Our Case Number: ABP-316119-23

Re: DART+ South West Electrified Heavy Railway Order - Hazelhatch & Celbridge Station to Heuston Station, and Hesuton Station to Glasnevin
County Dublin and County Kildare

16th May 2023

Re: DART+ South West Electrified Railway Order 2023 (An Bord Pleanála ref. 316119)

**WORKS LAYOUT PLAN
M50 AND PARK WEST
SCALE 1:1250 (@A0)**

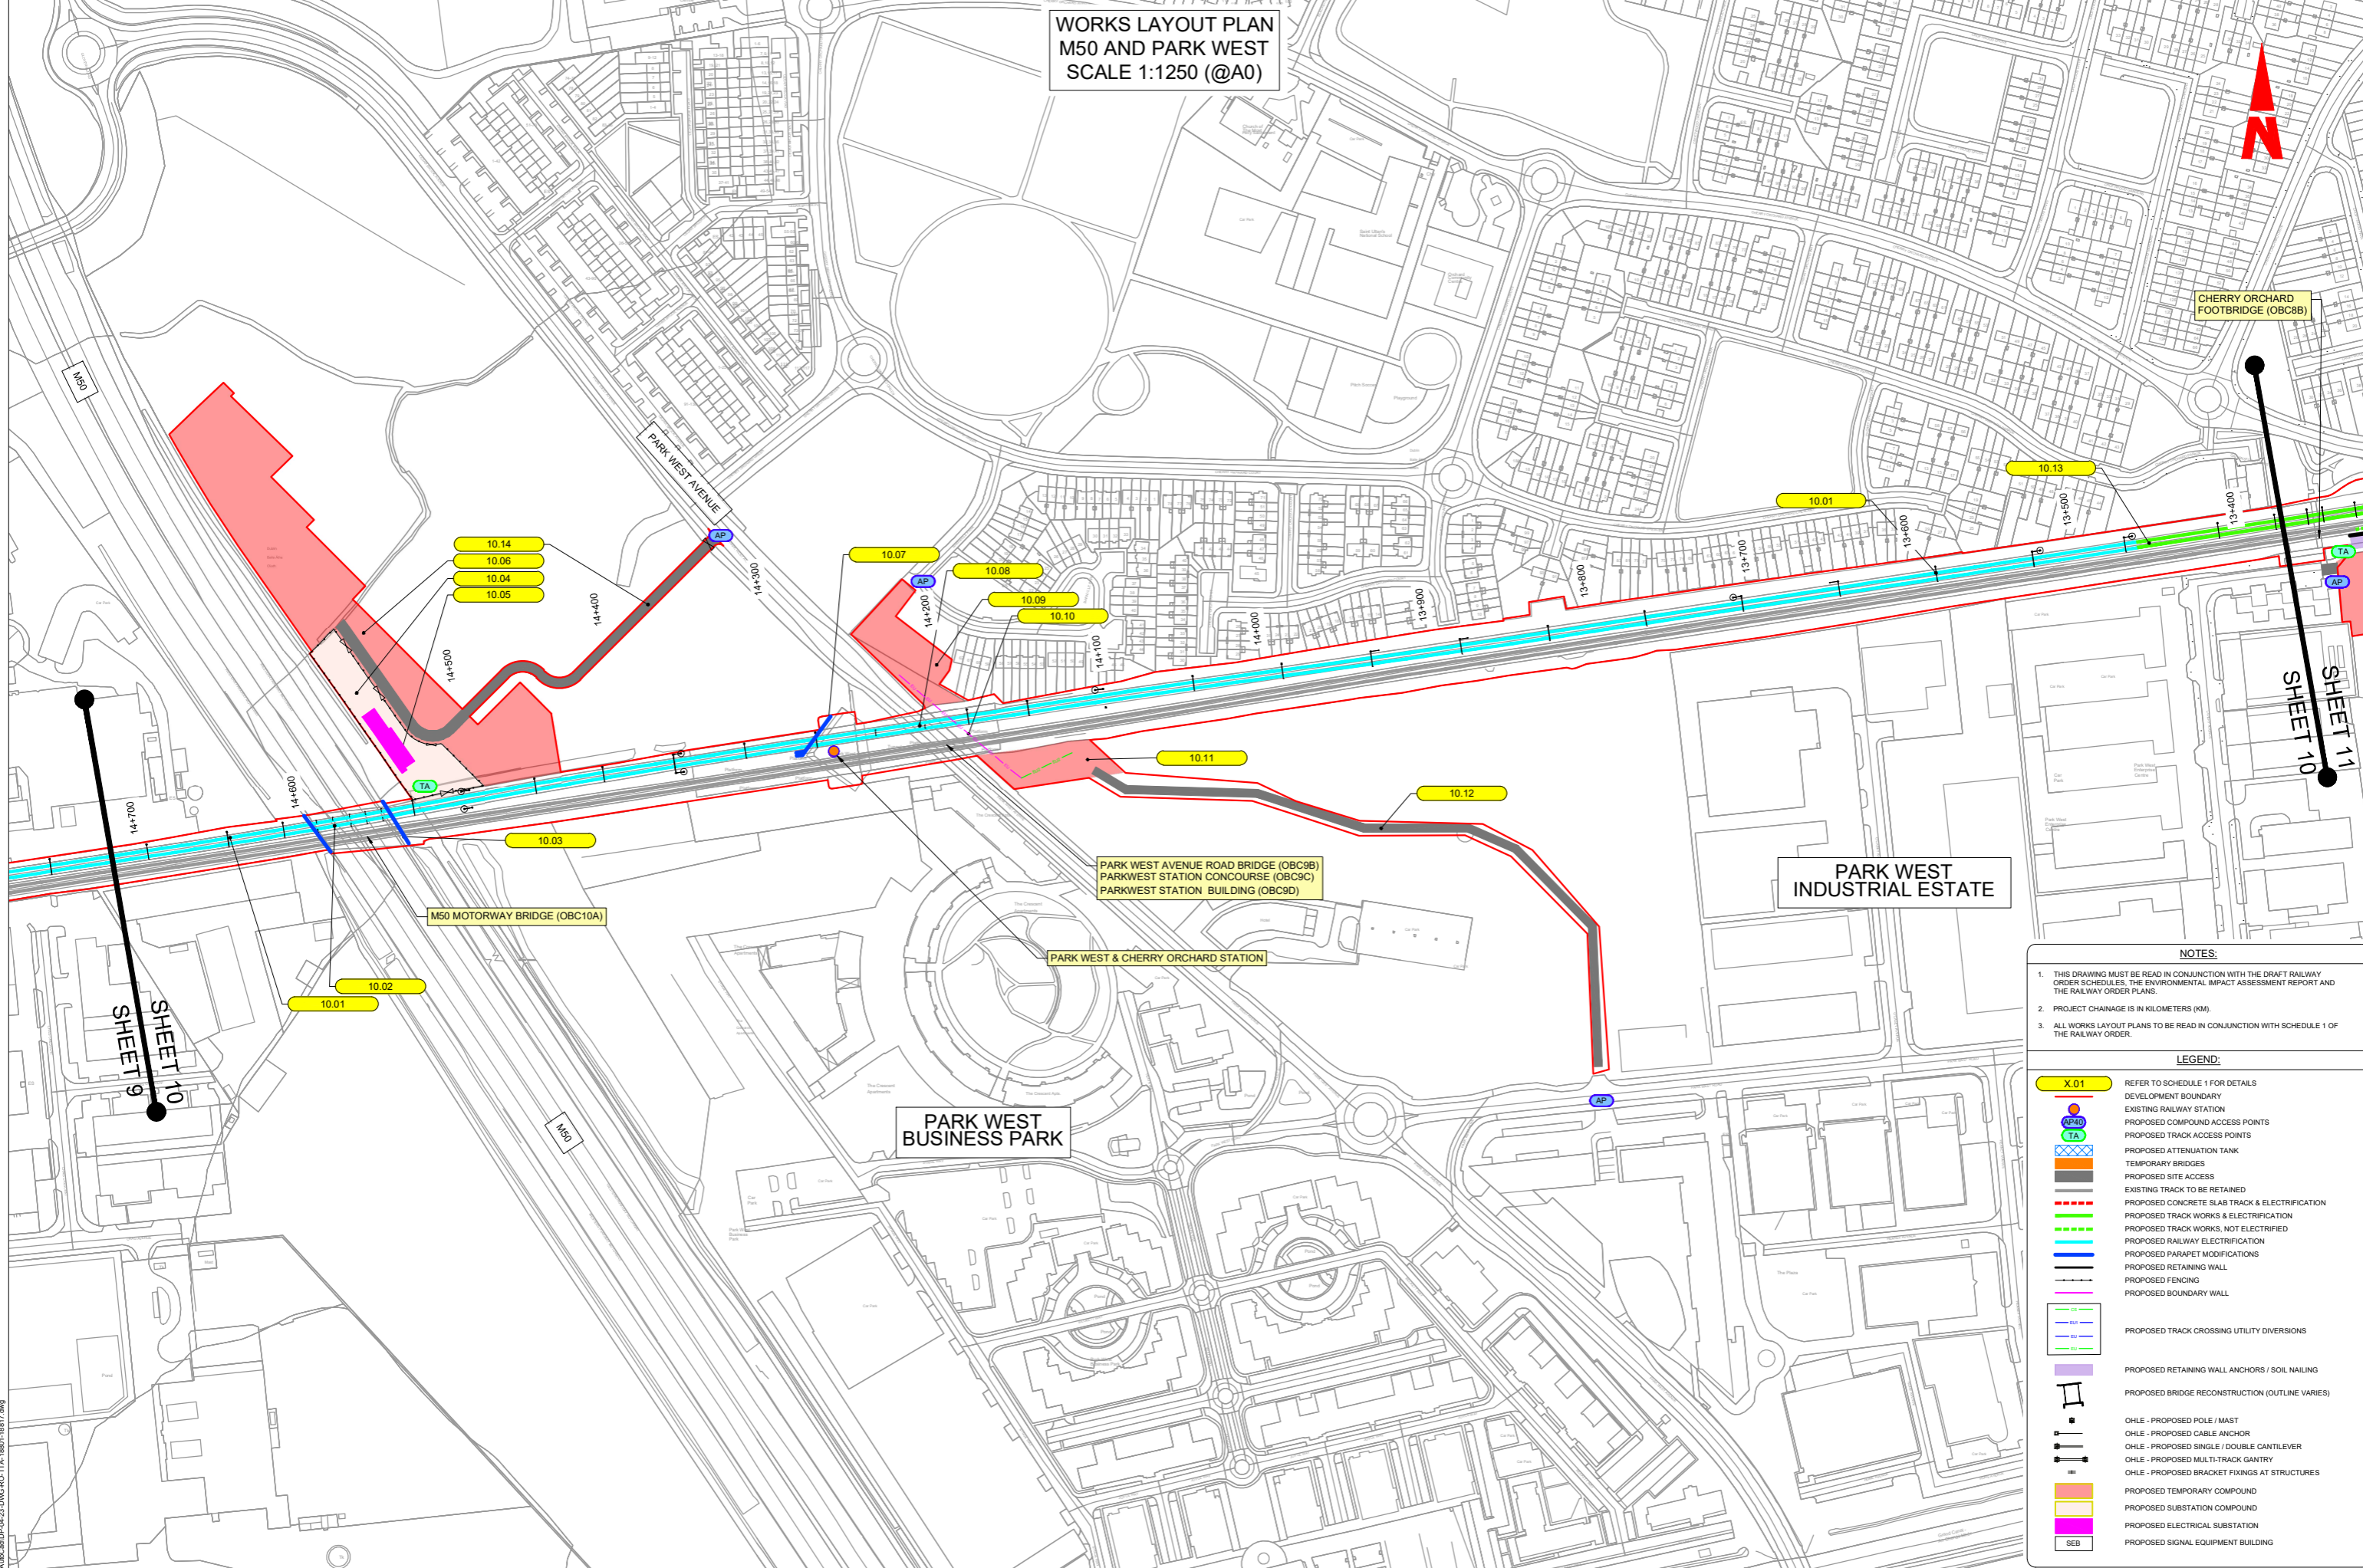
- 2.0 **Proposed temporary compound at Site 4**
- 2.1 Works Layout Drawing No. 10 submitted with the Railway Order shows a number of proposed works on the DCC/LDA Site 4. A proposed temporary construction compound is proposed along the west/south-west boundaries of Site 4 (Works No. 10.06). It is proposed that the temporary compounds will be required for the duration of the construction works/programme i.e. until 2029.
- 2.2 The LDA and CIÉ discussed and agreed the general location and size of the compound prior to submission of the Railway Order. This location will ensure the Phase 1 housing development site is not compromised. The LDA request that the location of the temporary compound as proposed on Works Layout Drawing No. 10 is retained as significant changes to this location will impact the LDA's mandate to deliver affordable housing at this site.

- 2.3 The LDA request that further consultation be carried out between LDA, DCC & CIÉ before and during the construction process to ensure the location of the temporary compound is appropriately located to ensure the construction of both projects can proceed with minimal impact to each other.

- 3.1 The temporary construction compound on Site 4 is to be in place for the duration of the Dart+ construction period (See Works No. 10.06 on Works Layout No. 10). As a result, it is likely that housing development proposed as part of phase 1 on Site 4 will be delivered in advance of completion of the railway works and will therefore be facing the temporary compound and construction hoarding. As a result, DCC and LDA would request that temporary landscaping on the outside of the compound hoarding be delivered to address the visual and noise impact likely to be caused to the phase one residential units. DCC/LDA request a high quality 3-metre-high hoarding with 2 metre strip of planting of fast-growing poplar and willow trees (10-12 cmg [Centimetre Girth]) be planted for the duration of the construction period and following this that they be removed and mulched on site at the end of construction.

4.1 Works Layout Drawing No. 10 submitted with the Railway Order shows a proposed gravel access road to service the proposed Park West Substation Compound and temporary construction compound. The road is to include the substation electricity cable supply (38KV infrastructure) route (Works No. 10.14). The proposed road and cable route follows the line of the permanent development internal road network proposed as part of the forthcoming Phase 1 planning application at Site 4 proposed by the LDA and DCC. Given this proposed internal road will be subject to a forthcoming planning application, the LDA are seeking to ensure that further engagement with CIÉ and other necessary stakeholders be ensured throughout the construction period. The LDA seek to ensure that the location and routing of the proposed temporary access road and cable infrastructure route be co-ordinated between all relevant stakeholders to ensure both the Dart+ and residential led development at Site 4 can proceed without conflict.

4.2 On behalf of the LDA, Waterman Moylan, Consultant Engineers, have reviewed the information submitted with the Railway Order and understand the 38KV substation proposed on Site 4 to serve Dart+ South West will require a two-circuit network connection. The drawings submitted show the proposed substation to the south west of Site 4 at Park West and only a short section of ducting which is noted as "possible route of 2 x 38KV incoming supplies from ESB – To Be Confirmed" (See Drawing title Park West Substation Location Plan and Layout - DP-04-23-DWG-RO-TTA-18856). The ongoing route of the 38KV infrastructure will likely have to be provided through the DCC lands (Site 4) to extend as far as Park West Avenue. Furthermore, it would also suggest that additional ducting will have to be provided through existing roads beyond the ownership of CIE/Irish Rail. Waterman Moylan understand a twin circuit 38KV duct cross section will require a 900mm wide and 1200mm deep service trench through which other services will not be allowed to run (see example of service trench below in Figure 4). Other services may run alongside the 38KV twin circuit cross section, however. The LDA would request that the final alignment of the proposed electricity infrastructure routing follow the proposed road centreline in order to minimise impact on and allow space for additional necessary infrastructure to serve the overall development of Site 4.

5.2 The LDA wish to make a number of comments regarding the proposed substation and permanent compound. Presently, the existing tree planting along the M50 within Site 4 provide a landscaped buffer to the site. The LAP also seeks a 'green buffer zone' along this boundary with the M50 as part of a 'green corridor'. The proposed substation will permanently remove some of the existing trees and hedgerows. The LDA would request that some form of permanent tree and/or landscape planting be proposed either outside or inside the eastern and northeastern boundary fences of the substation to ensure a landscape buffer is provided to Site 4. This will ensure the green buffer is provided as sought by the LAP and will mitigate the visual impact of the substation which will in future be located opposite housing and commercial development at Site 4. The following options are suggested (see Figure 5 for illustration):

Option 1: Consider moving the proposed boundary palisade fence 2 metres inside the ESB compound on the eastern side to allow for widening of the bio retention planting strip to 3.5 metres to accommodate tree planting to mitigate the visual impact of the compound and loss of existing trees in that zone.

Option 2: If no opportunity for planting within compound area, consider at least a 1 metre wide planting space along the fence line to the inside of the compound to allow for hedge planting (hedge to be planted on the inside of the compound to prevent people from climbing on the hedge and over the fence).

- 6.1 Works Layout Plan No. 10 proposes a temporary construction compound at Site 5 of the Park West-Cherry Orchard LAP. Site 5 is to be brought forward in a further planning application phase following the submission of the phase one planning application at Site 4. The temporary compound is required for directional drilling works. The location of this temporary compound conflicts with a proposed block shown in the on the Site 5 'Site Brief' within the LAP. DCC and the LDA would request that the location, extent, access arrangements and duration for this temporary compound are discussed prior to construction of the Dart+ project. This is to ensure that detailed proposals and a planning application for Site 5 housing development can be development while ensuring minimal conflict with the Dart+ proposal.
